From: Karl Roberts <Karl.Roberts@arun.gov.uk>
Sent: 20 December 2019 10:06
To: Planning.Responses <Planning.Responses@arun.gov.uk>
Subject: FW: A/100/19/PL - Arundel Acre - response to Highways England and WSCC

From: Ian Hayward [REDACTED]
Sent: 06 December 2019 12:59
To: Karl Roberts <Karl.Roberts@arun.gov.uk>
Subject: RE: A/100/19/PL - Arundel Acre - response to Highways England and WSCC

Visibility North & Highways England:

WSCC (LHA)

RPS Drawing/Figure Number	Rev
JNY10317/01a	-

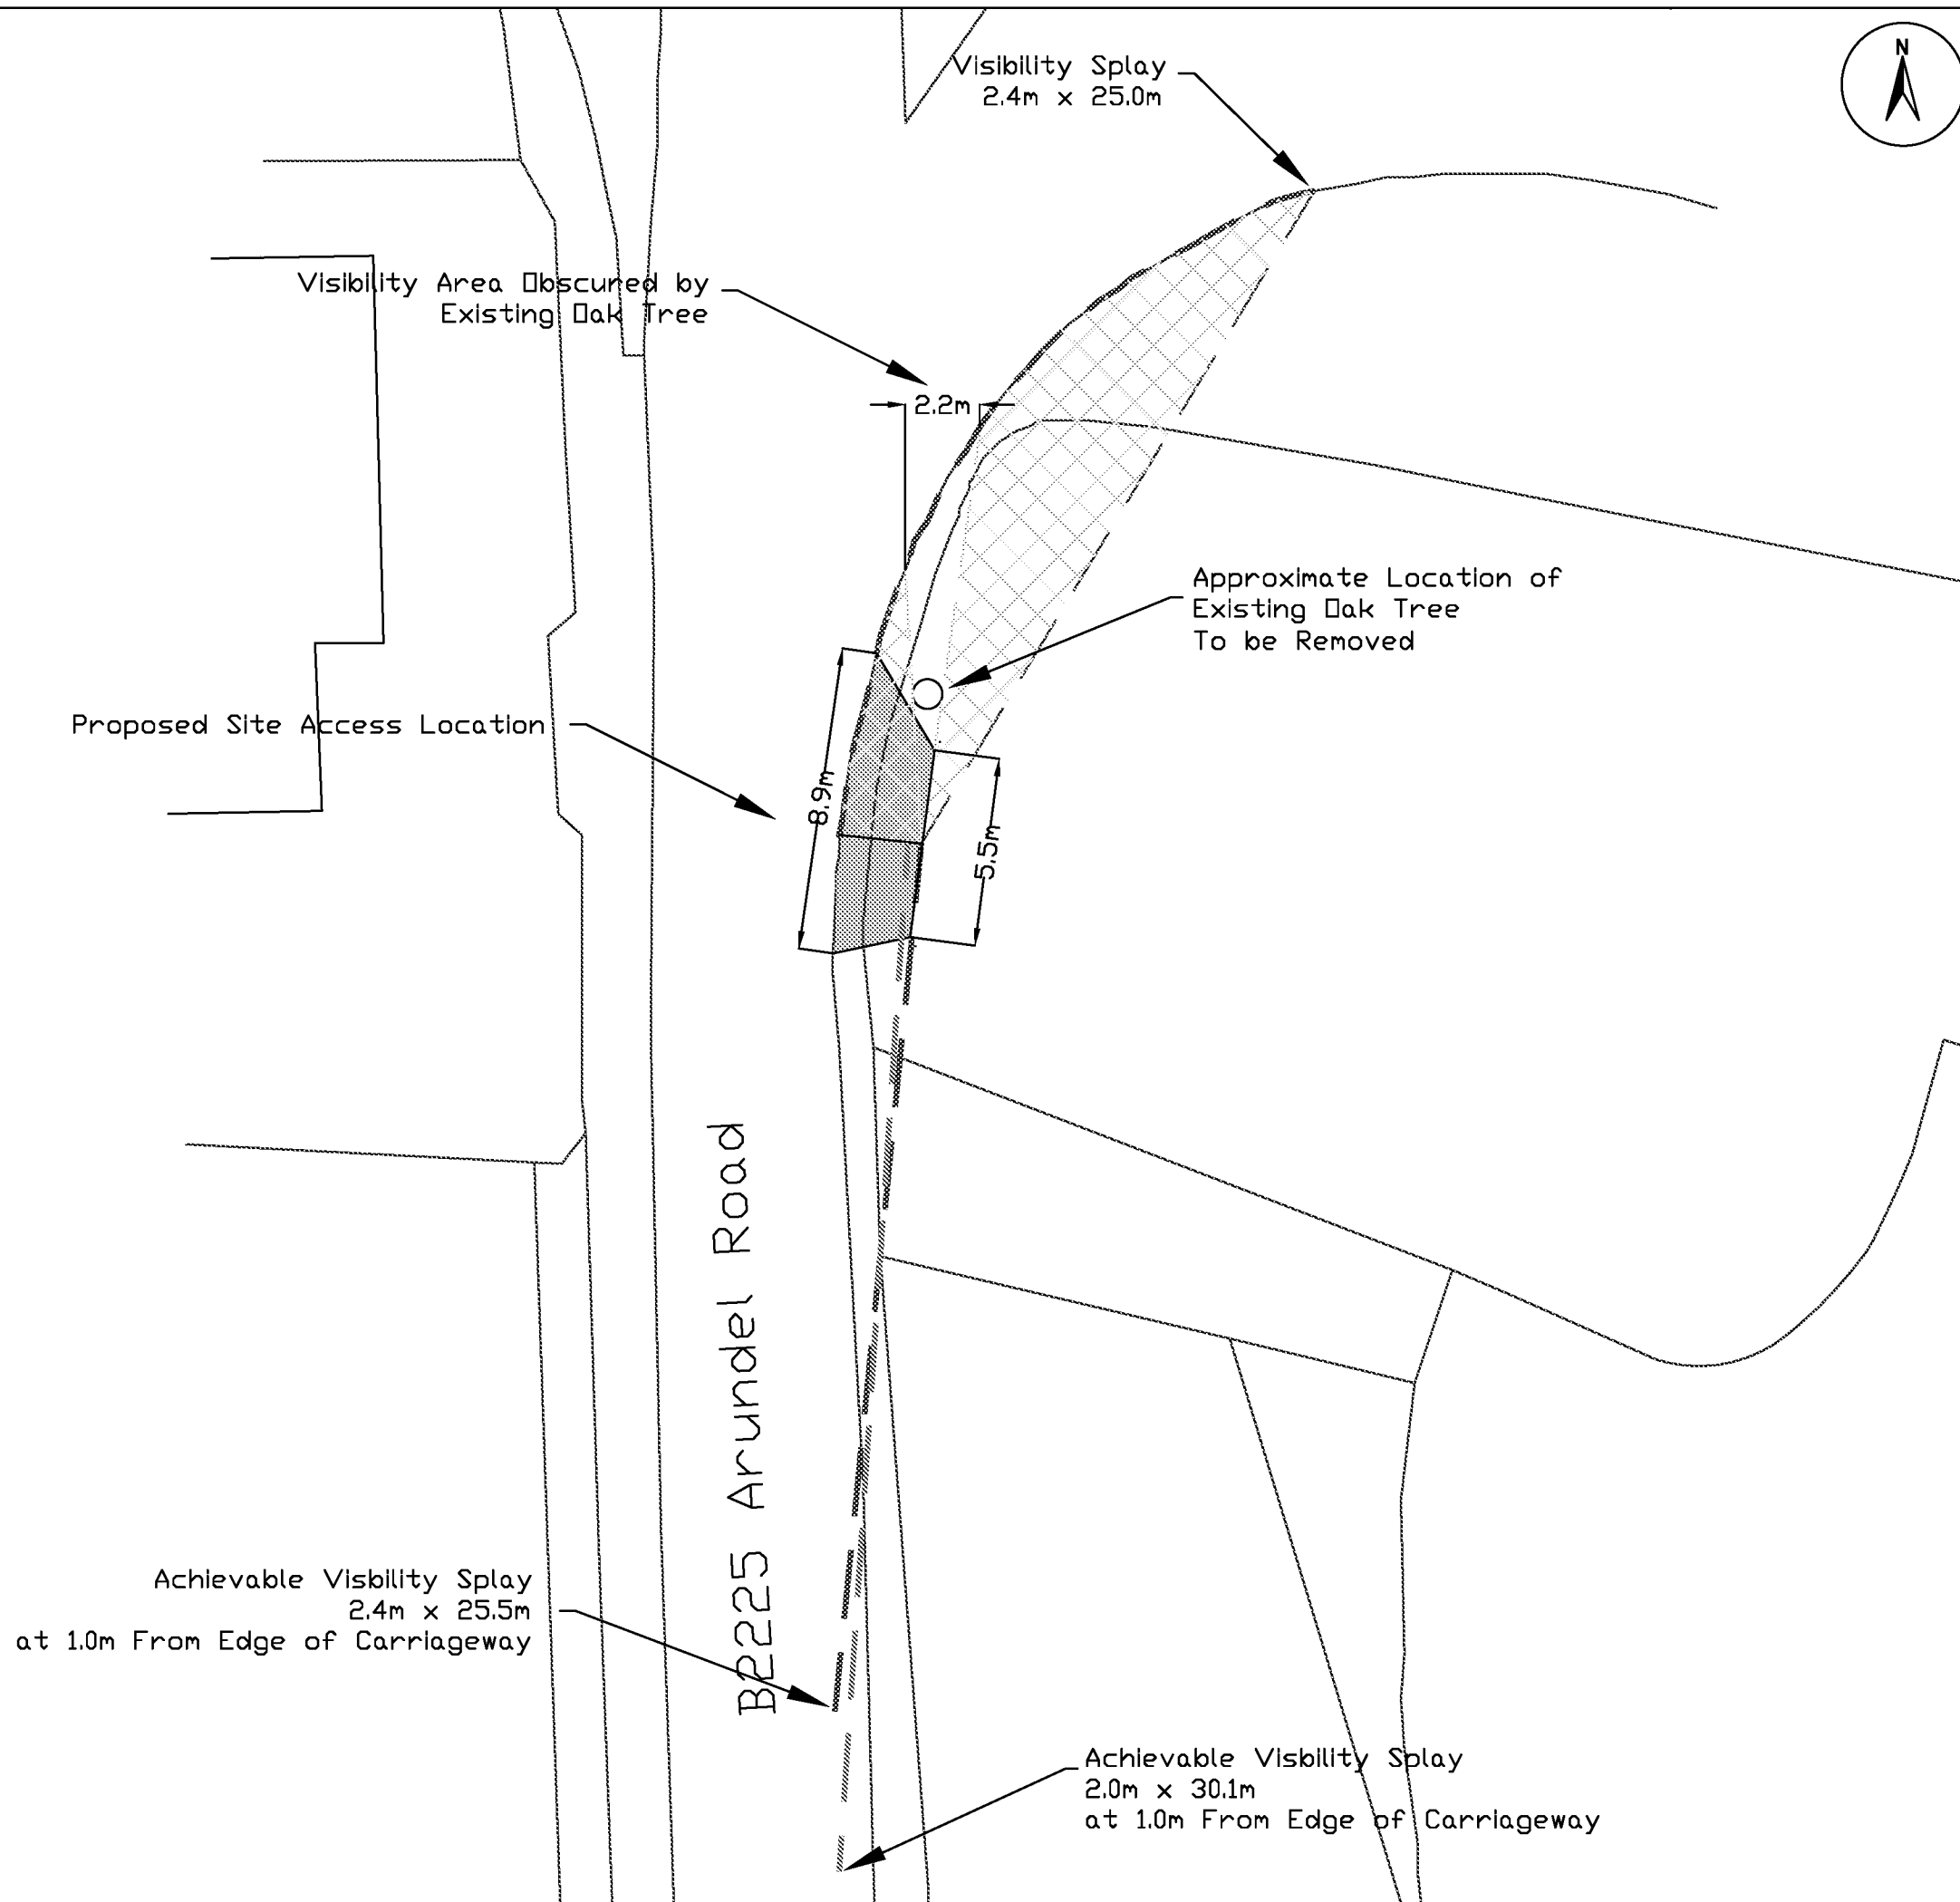
- ii) The Local Highways Authority accepts that subsequently additional plans submitted represent the site and surrounding road network accurately. However is minded to view that the submitted block plan (unnamed but dated 03/07/2017) does not represent the surrounding highway network accurately, particularly the junction with A27.

- ii. **The block plan is not representative of the road layout and the deceleration lane would result in higher speeds approaching the access point** – Submitted drawing No. JNY10317/01a is based on OS mapping and accurately shows the road layout. Although lane delimitation is not shown, the submitted ATC, plans and supporting documents provide, in our view, an appropriate level of detail to allow the LHA to assess the proposal, with the ATC providing specific detail regarding speeds.

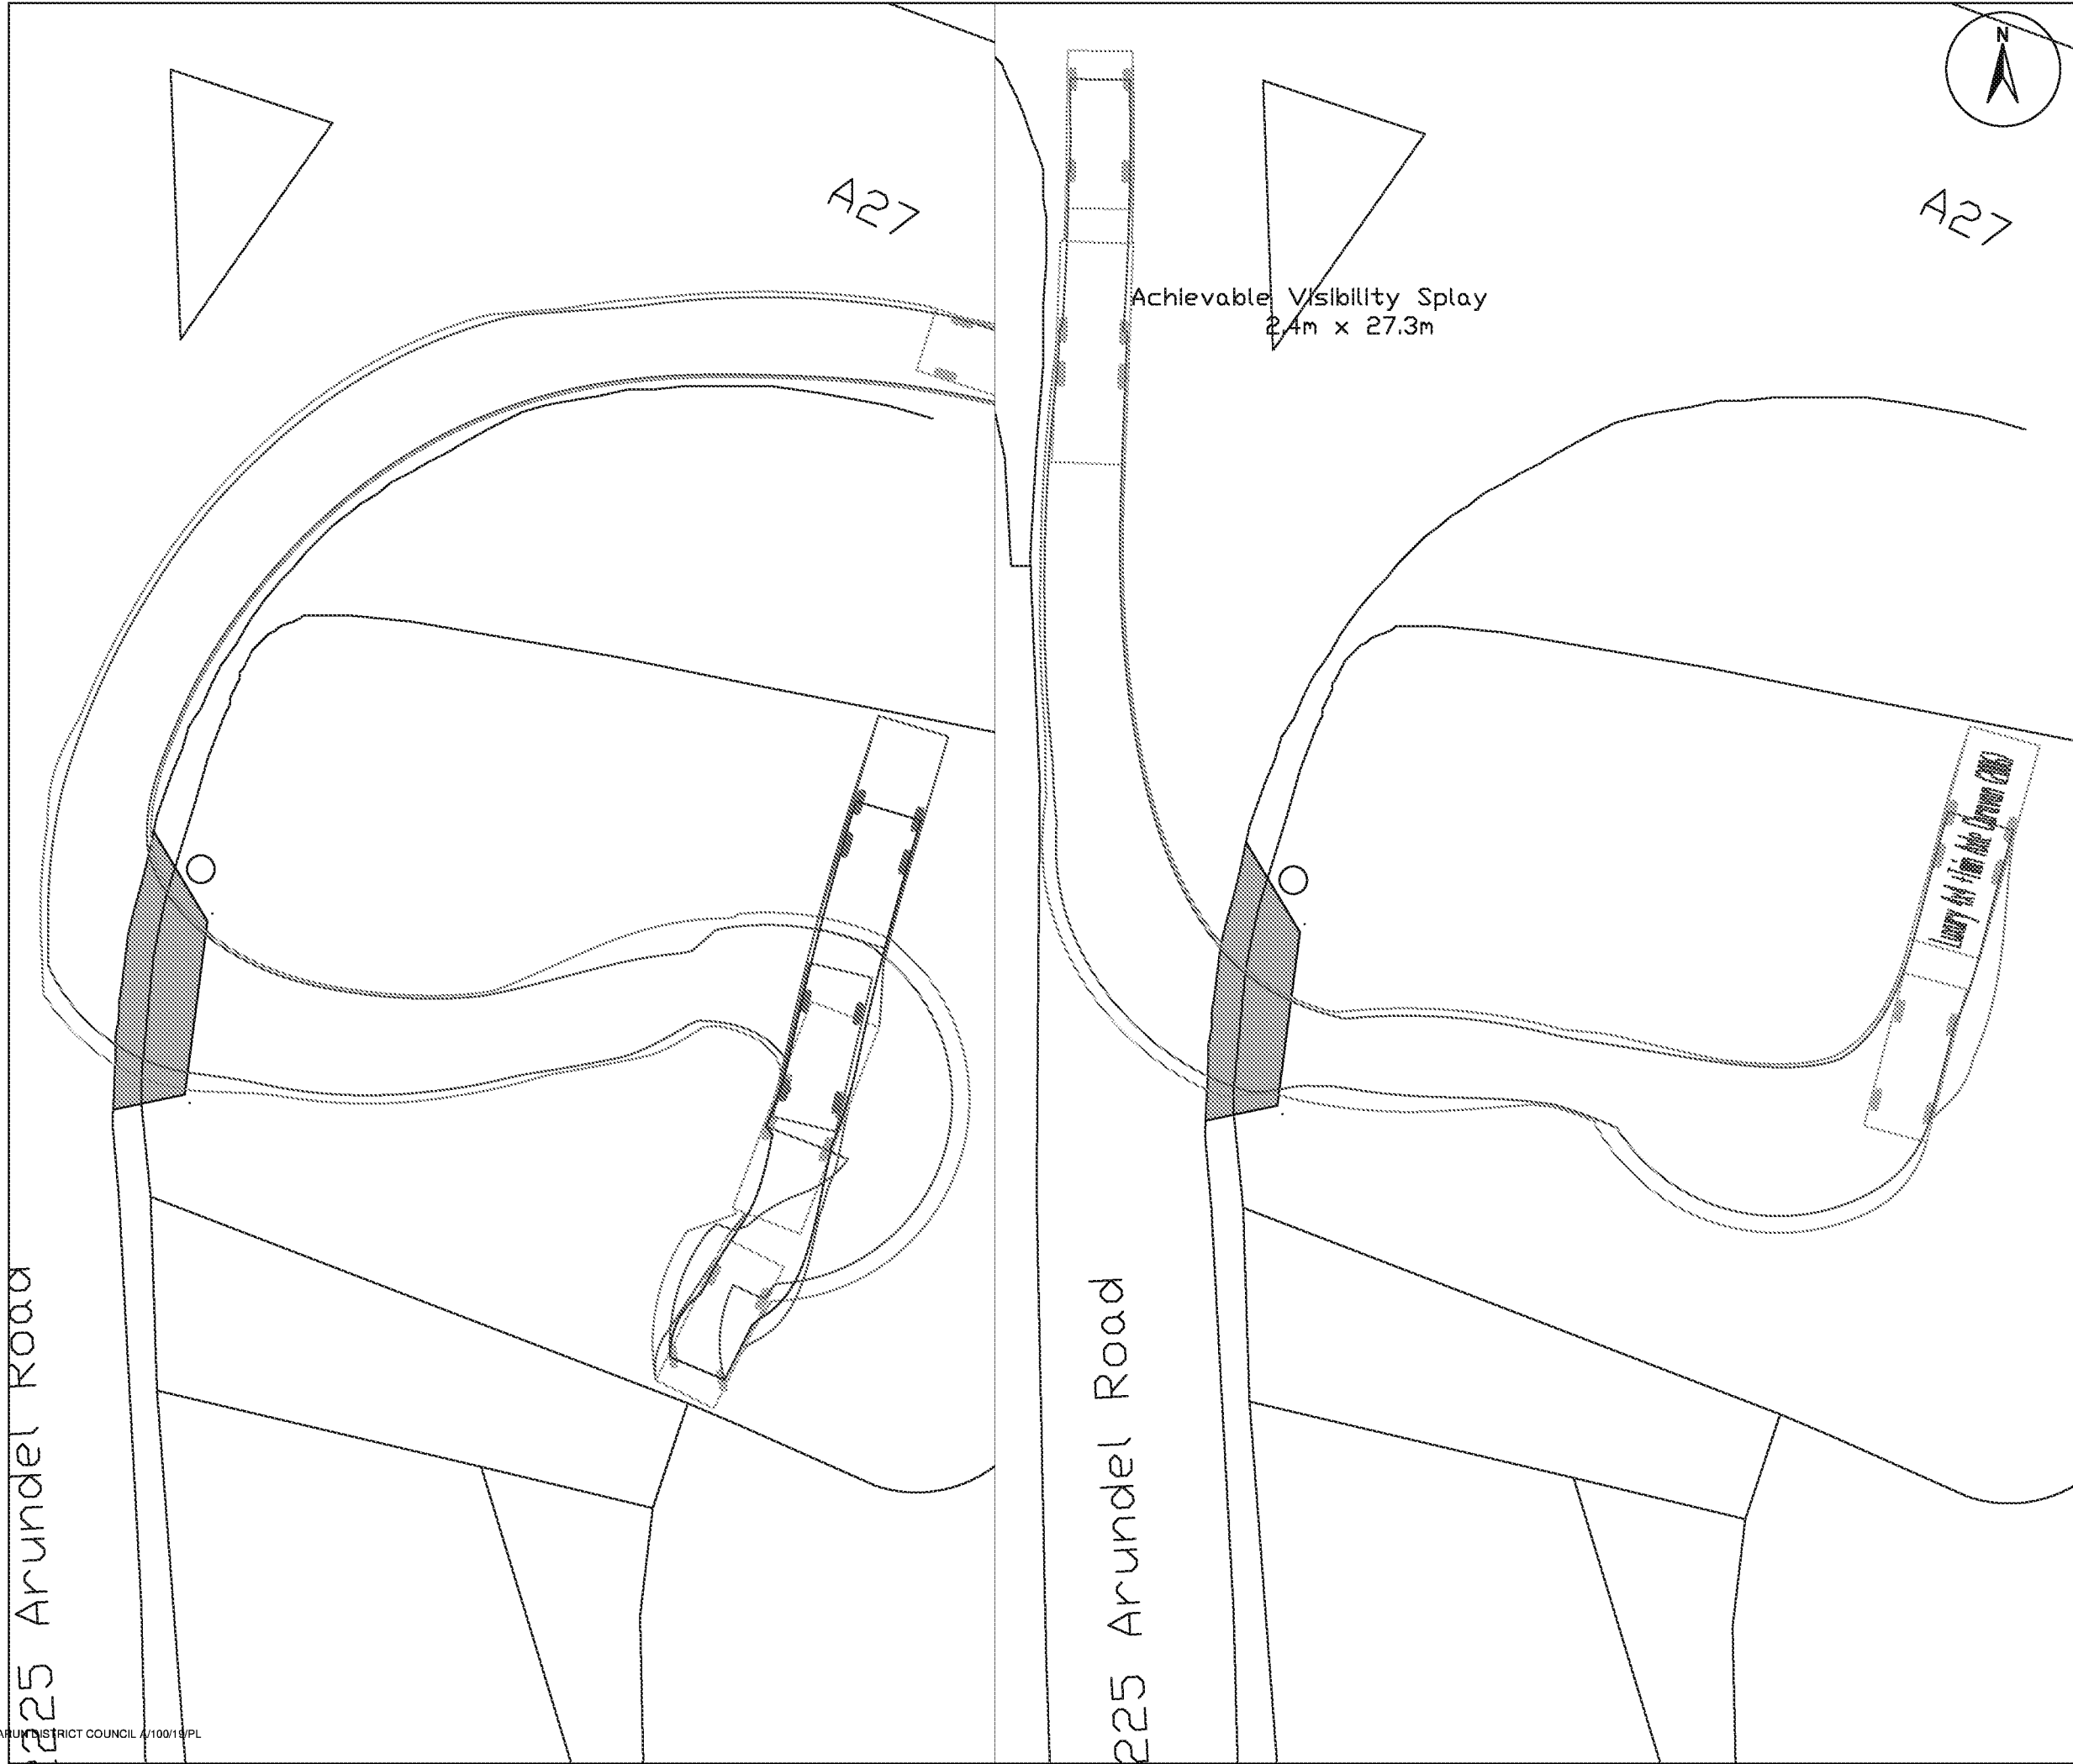
- v) The statement made in Paragraph 10.5.9 of Manual for Streets 2 (attached below) references a research study. This study was undertaken using a series of high-risk, urban, established priority junctions, of which the application site access is not. It is therefore questionable how applicable this paragraph is in this particular case. The

research was also undertaken using a 2.4 metre 'X' distance for which only the demonstrated 25.5 metre splay would be considered applicable for comparison. While there is no local, evidence to the contrary, accident data etc., there would not be expected to be any given the low trip generation the access has yielded with its current use.

- v. **The southern splay is significantly short of what would be expected given the approaching road speed, with MfS requiring a stopping sight distance (SSD) of 50m** – The southern visibility splay would be able to achieve SSD between 25.5m – 30.1m and given other site’s constraints, this would be the maximum achievable on site. It is the case that Paragraph 10.5.9 from Manual for Streets 2 indicates that, although the ‘Y’ distance of a visibility splay should be based on the recommended SSD, *“unless there is local evidence to the contrary, a reduction in visibility below recommended levels will not necessarily lead to a significant problem.”* Taking into consideration: i) the number of two-way vehicular trips which will result from trailers or large vehicles will be less than 0.1 per day; ii) the nature of this part of the road, where there exist residential accesses with limited visibility which are similar in scale and nature to the proposed residential movements to be generated from the proposal, as well as the existence of a caravan park to the south of the site which possibly generates a higher number of larger vehicles coming in and out of the site and iii) the lack of parking restrictions on the road, essentially meaning that vehicles are capable of parking on the road thus potentially reducing vehicle speeds; we

are of the view that local circumstances clearly exist to conclude that a reduction in visibility below the recommended level will not lead to a significant problem.
